Your Ref:
CM/1/11/
Our Ref:
S/AR/2011/1
Date: 22/03/2011

Proposal: Demolition of 5 no. existing B2 commercial buildings & erection of 1 no. new commercial building (this application is a departure from the development plan).

Site: Ryebank Farm, Gravetts Lane, Climping BN17 5RQ.
CM/1/11/

PROPOSED SITE PLAN 1:500@A1

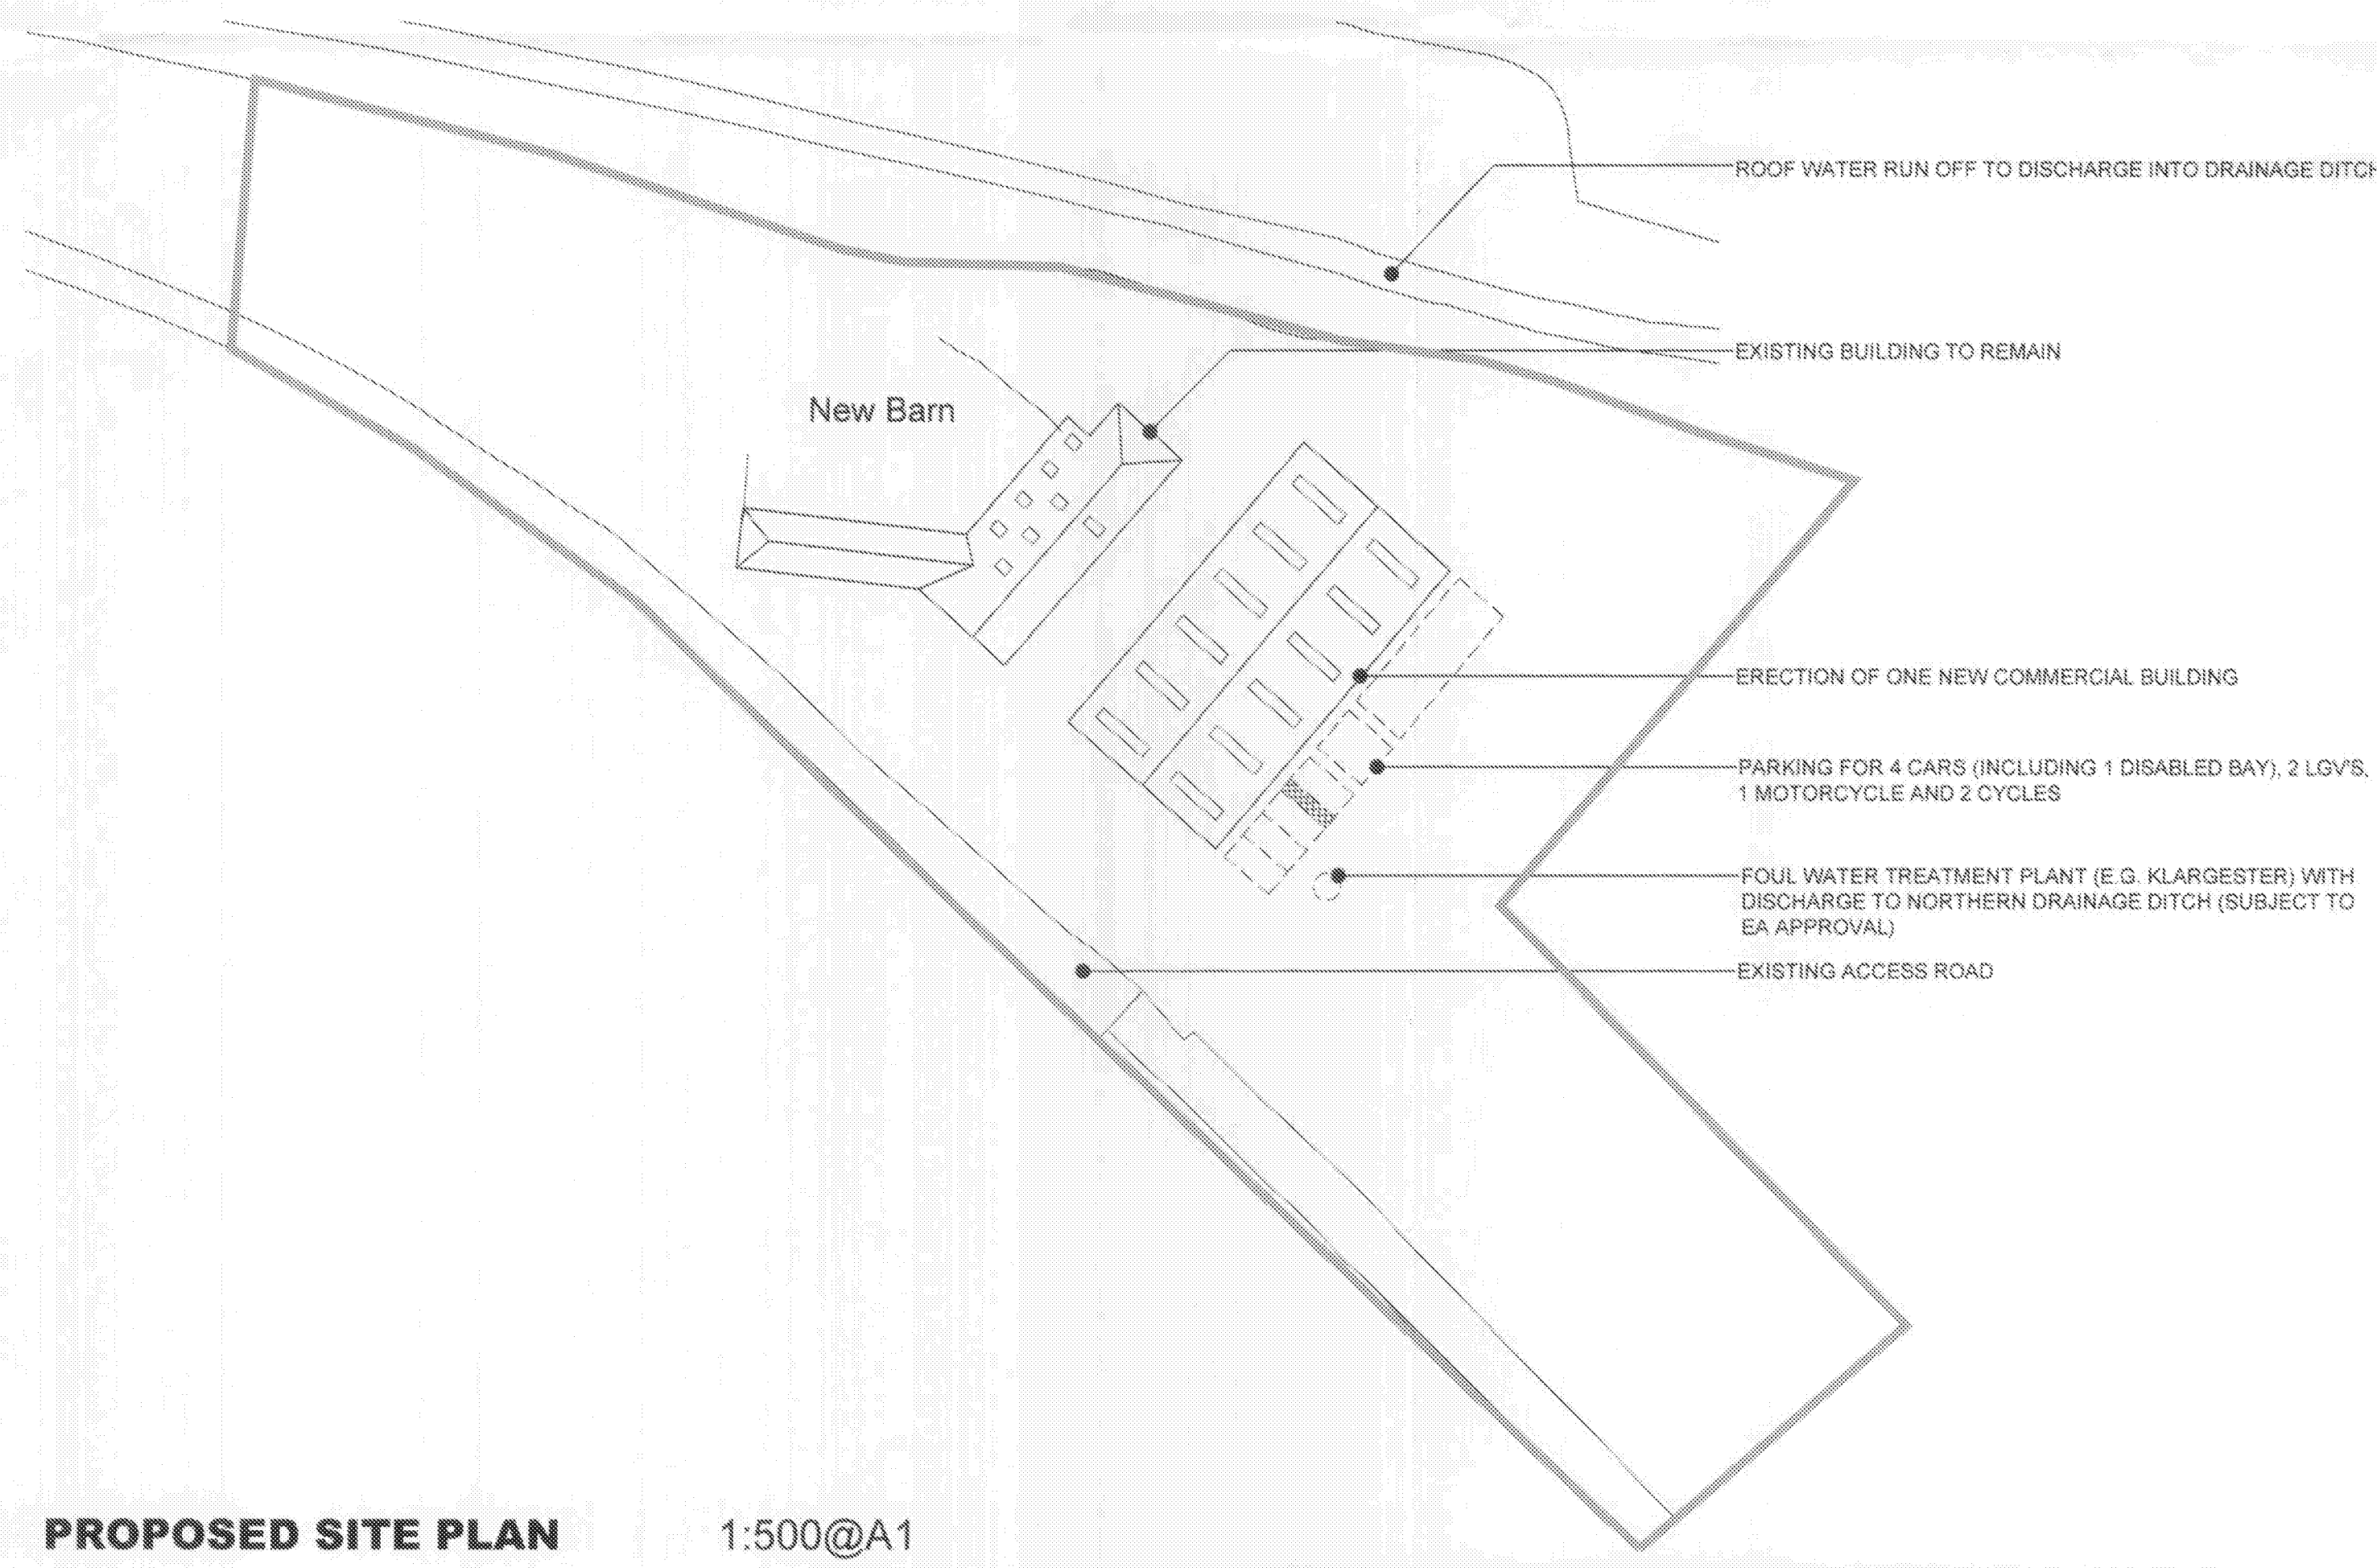
Please find attached a plan of the sewer records showing the approximate position of a public rising main within the boundary of the site. The exact position of the public sewers must be determined on site by the applicant before the layout of the proposed development is finalised. Please note:

No development or new tree planting should be located within 3 metres either side of the centreline of the public sewer and all existing infrastructure should be protected during the course of construction works.
